CITY OF ALBUQUERQUE

July 22, 2019

RE: **BEK Distribution Facility – 601 Gallatin Pl. NW**
G&D Plan and Drainage Report Engineers Stamp Date: 7/19/2019,
Hydrology File: FJ10D002G1

C203

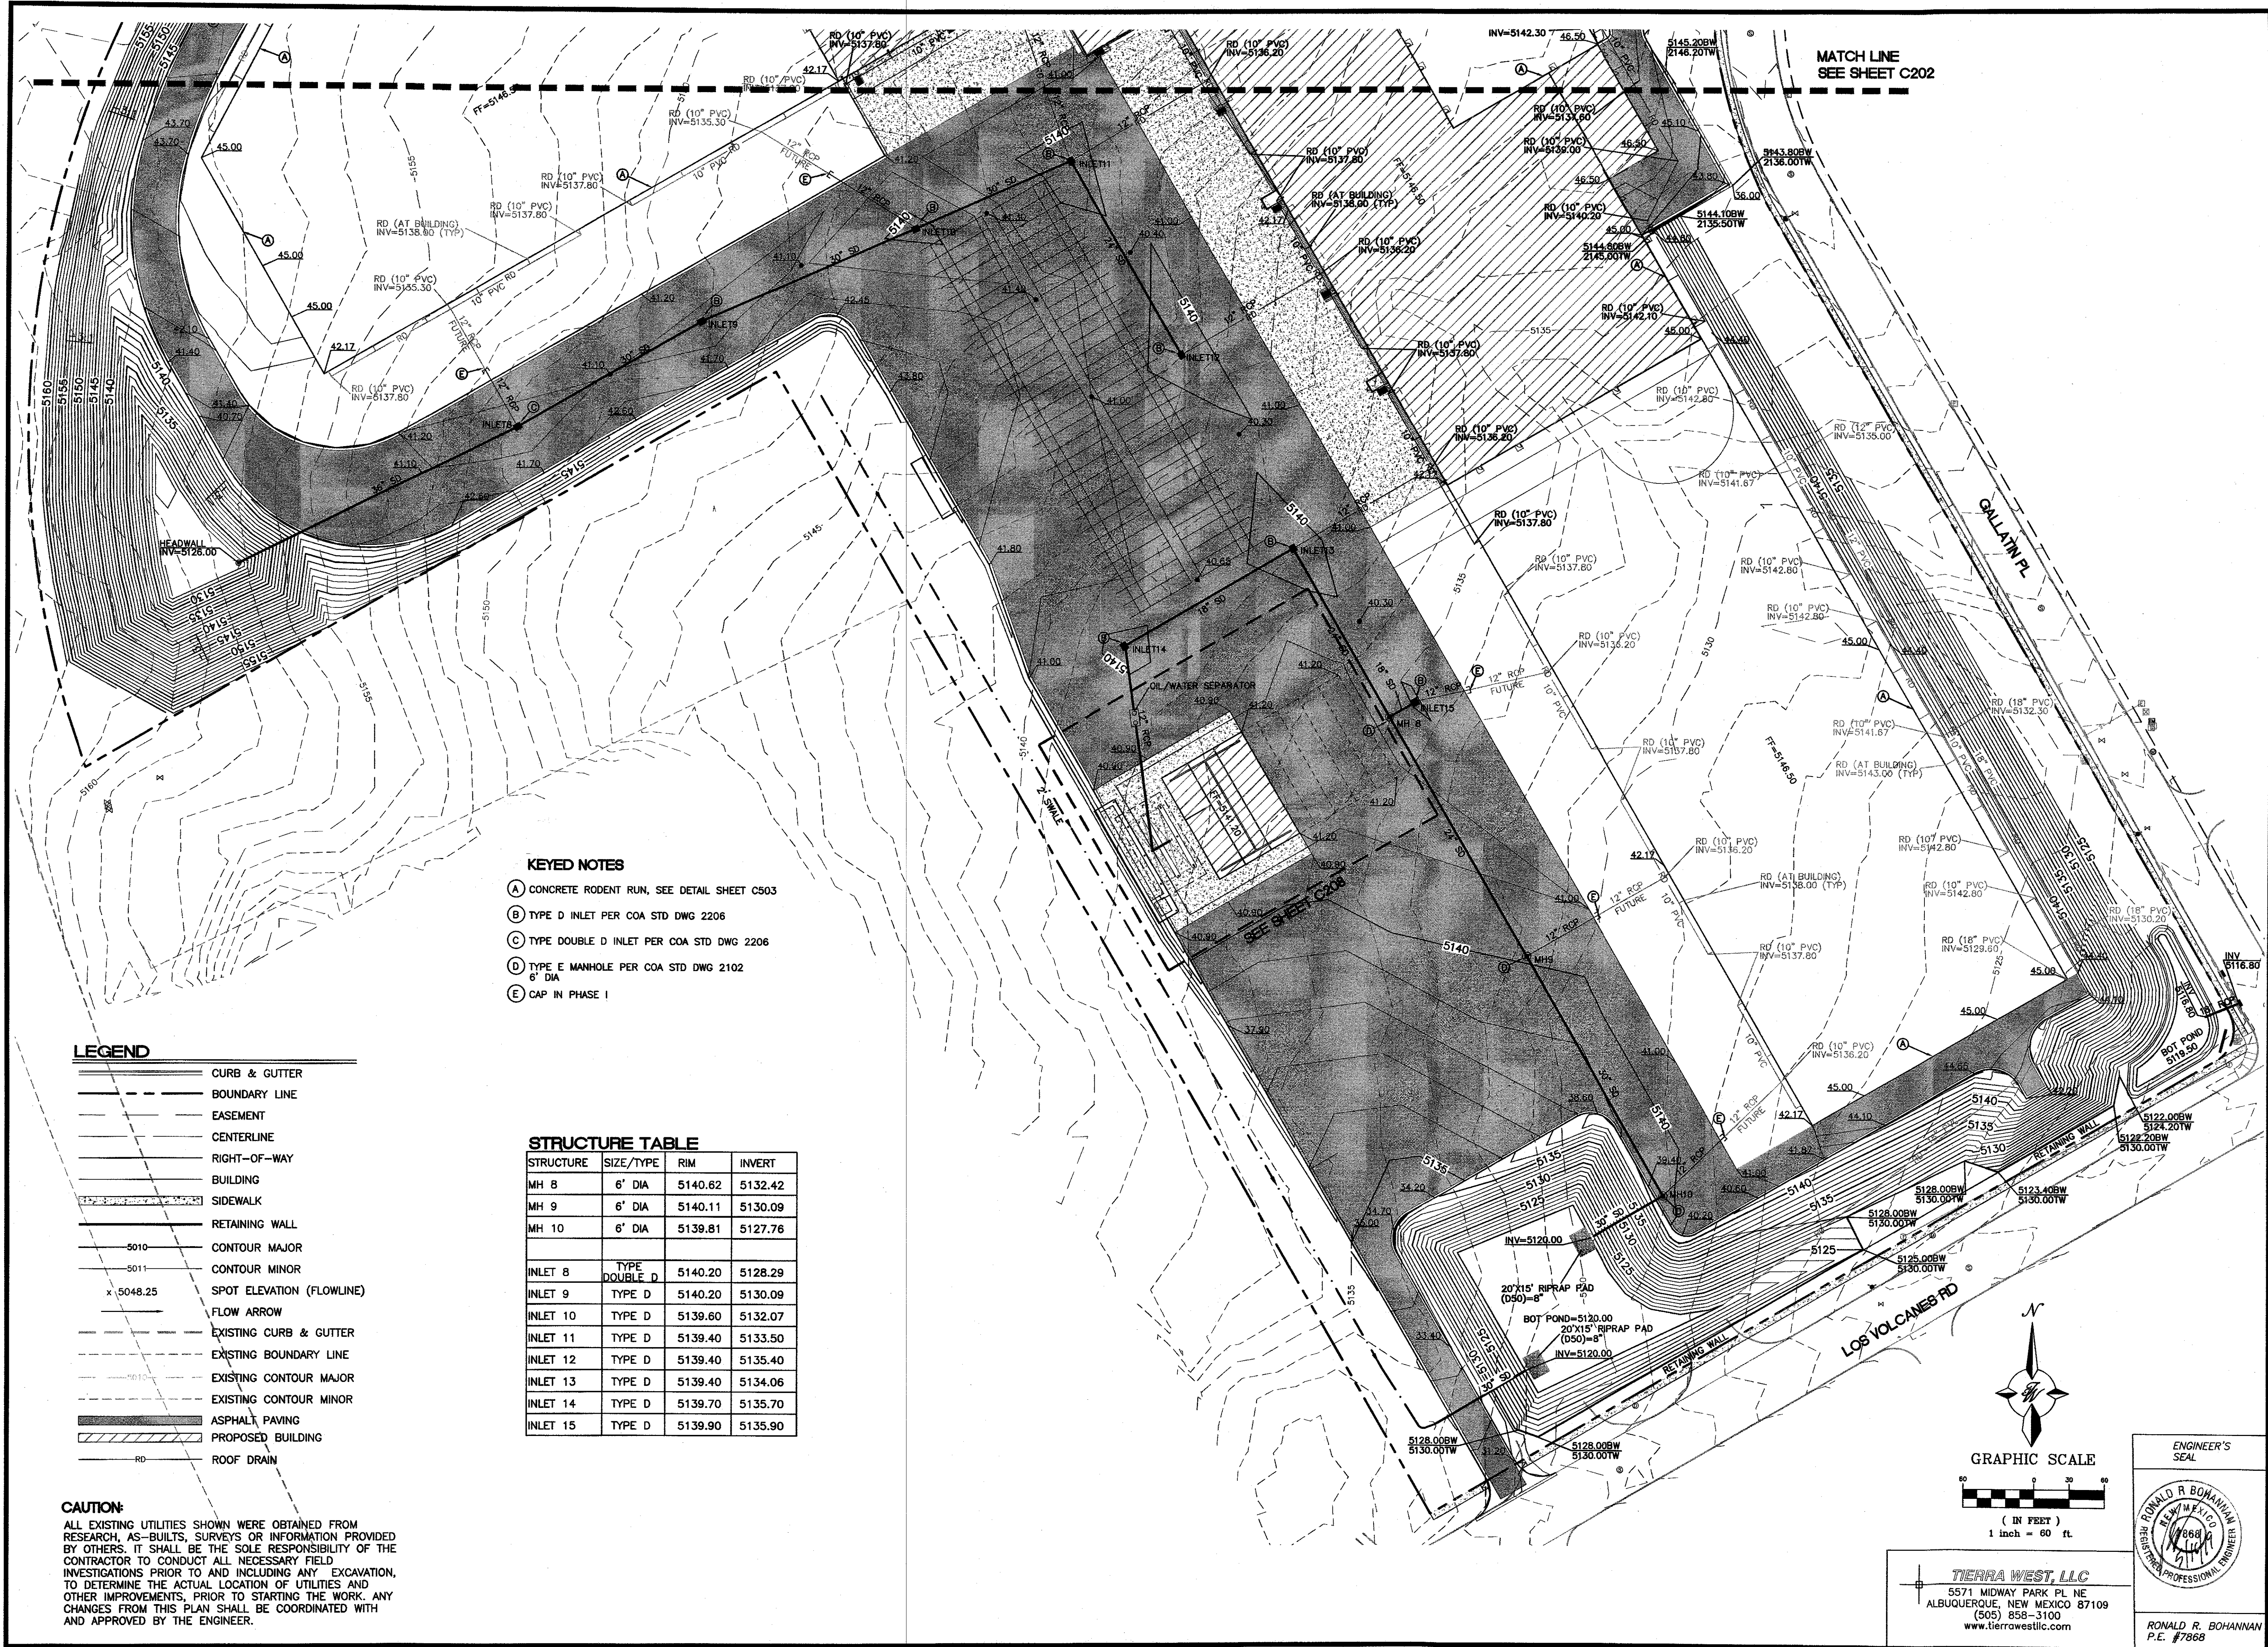
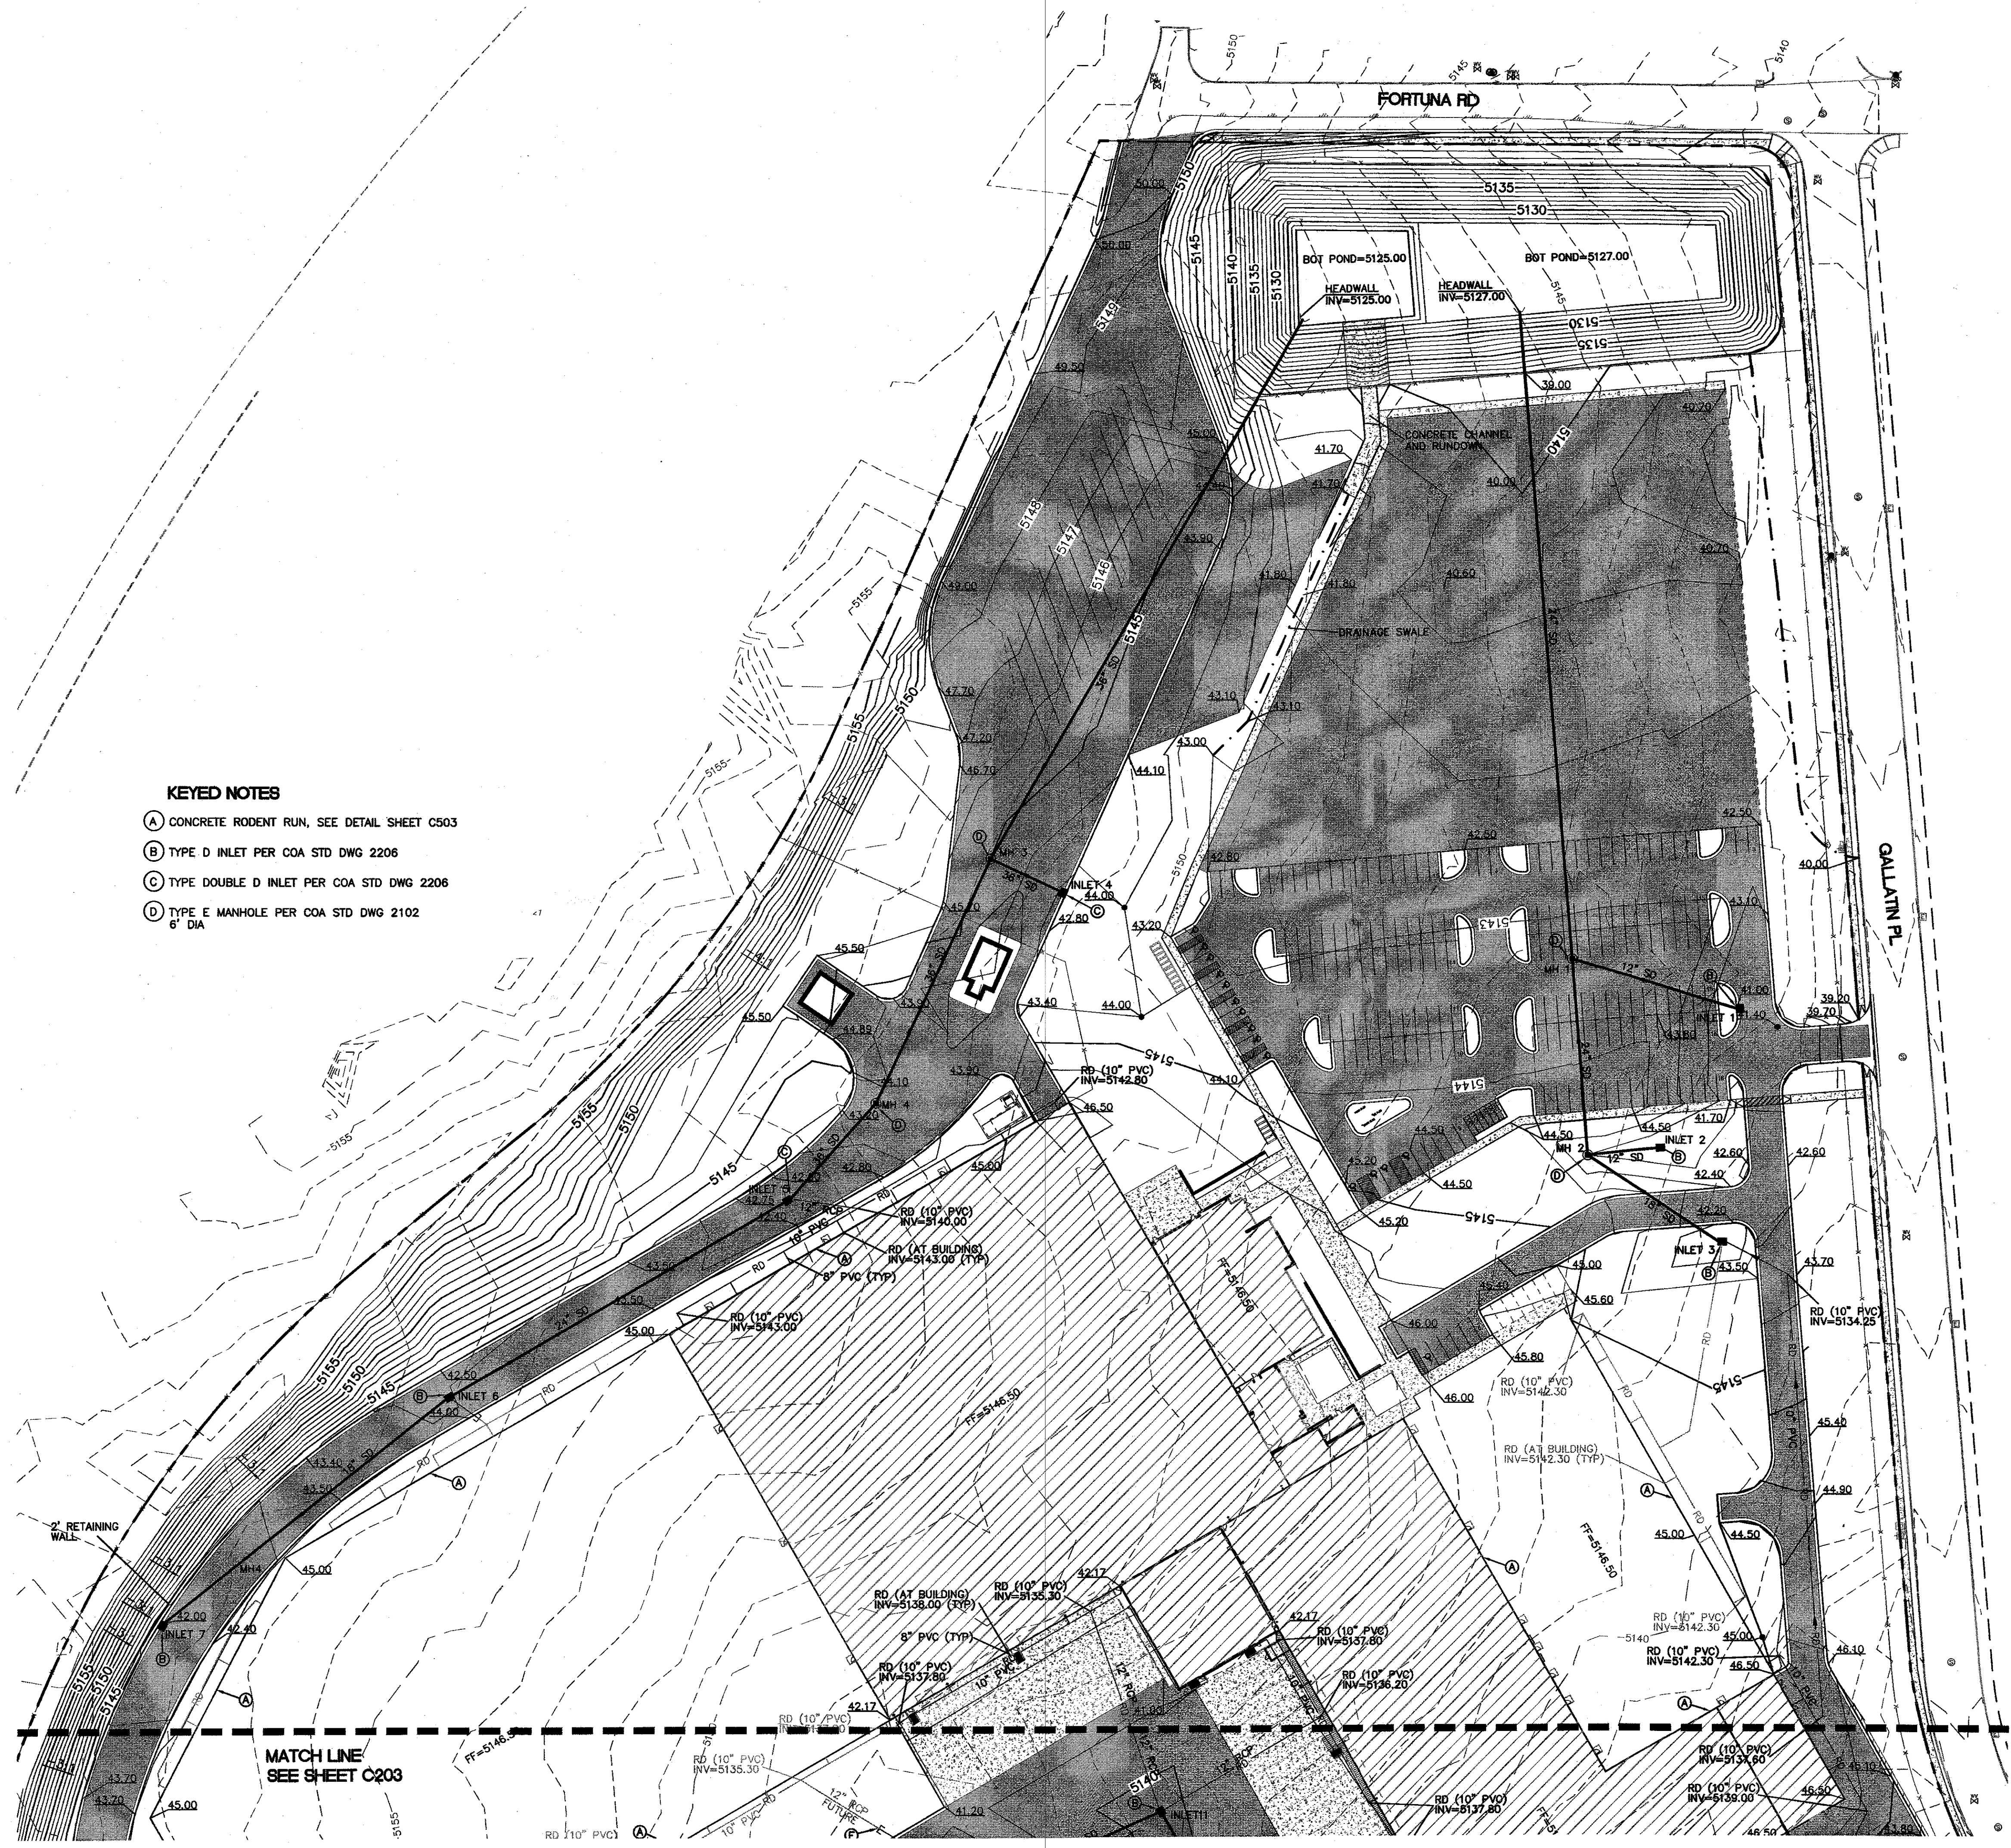
- c. The existing Dam may encroach on this site. A minimum 6' wide top of dam must be maintained. Section A-A on sheet C203 may need to be updated with the results of the revised survey and hopefully get the dam off of the BEK property and back onto the Coca-Cola property.

STORM SEWER  
PLAN AND PROFILE

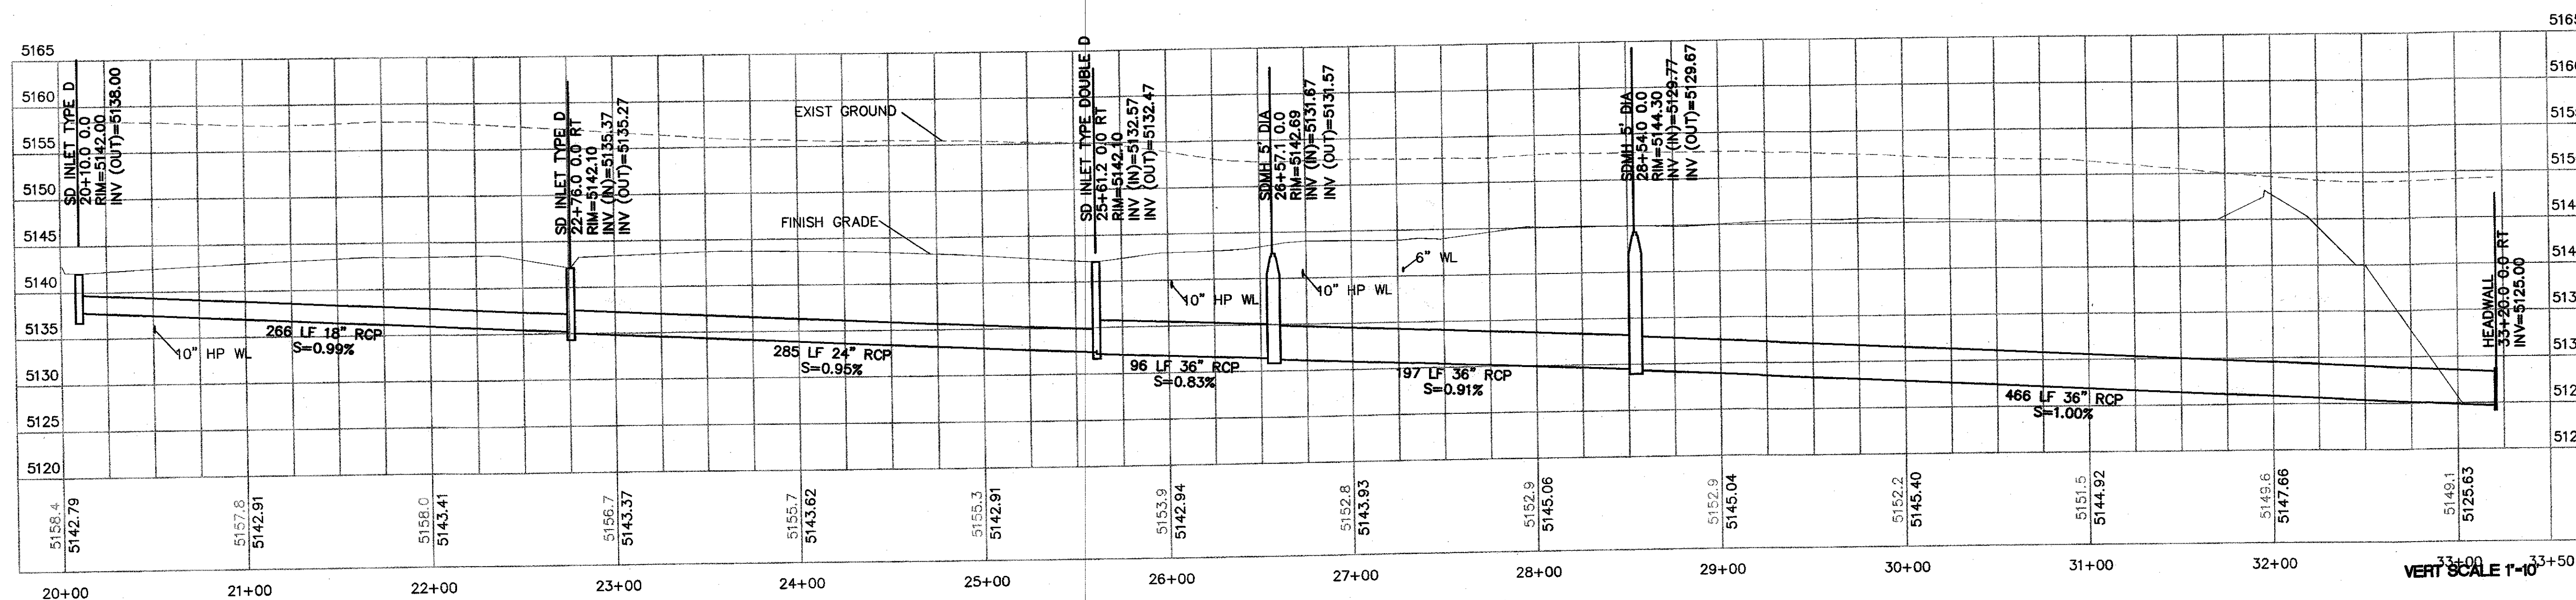
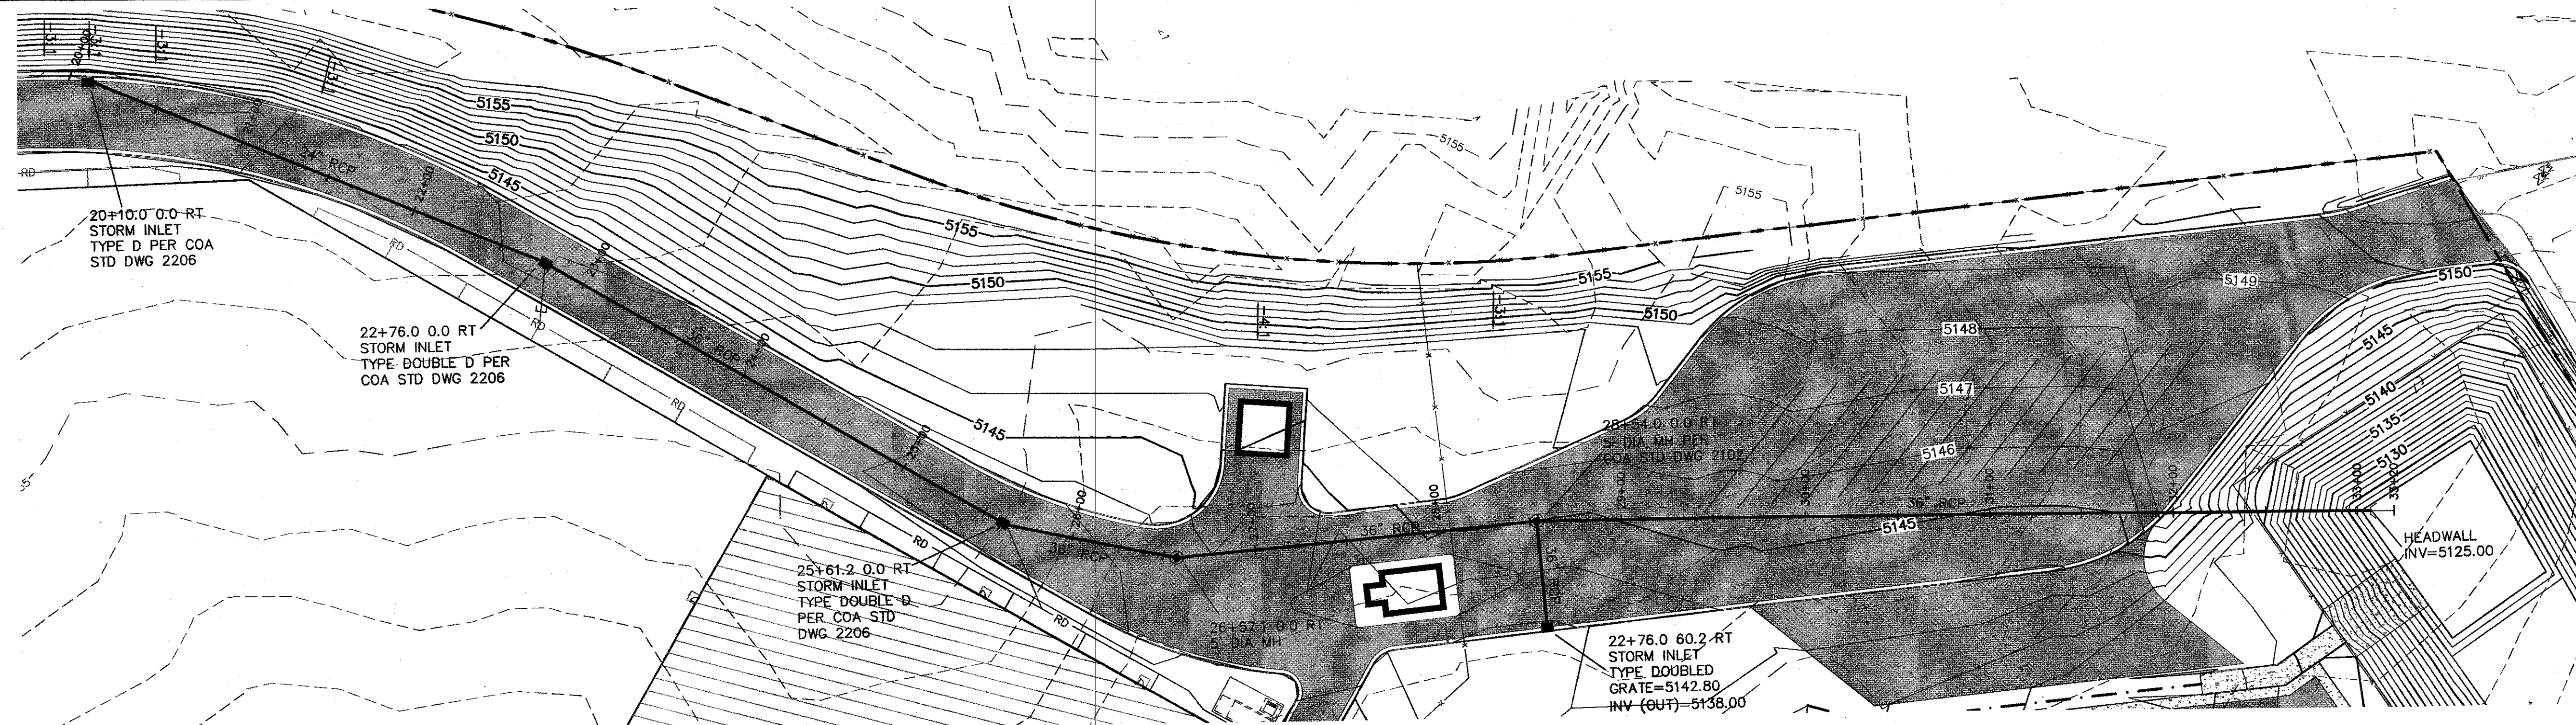
11. HGL calculations are required for the storm drain in the north east corner of the site where failure of the storm drain could result in excessive stormwater runoff to public streets. Also please add a profile and HGL calculations for the storm drain on the south and east side of the building.
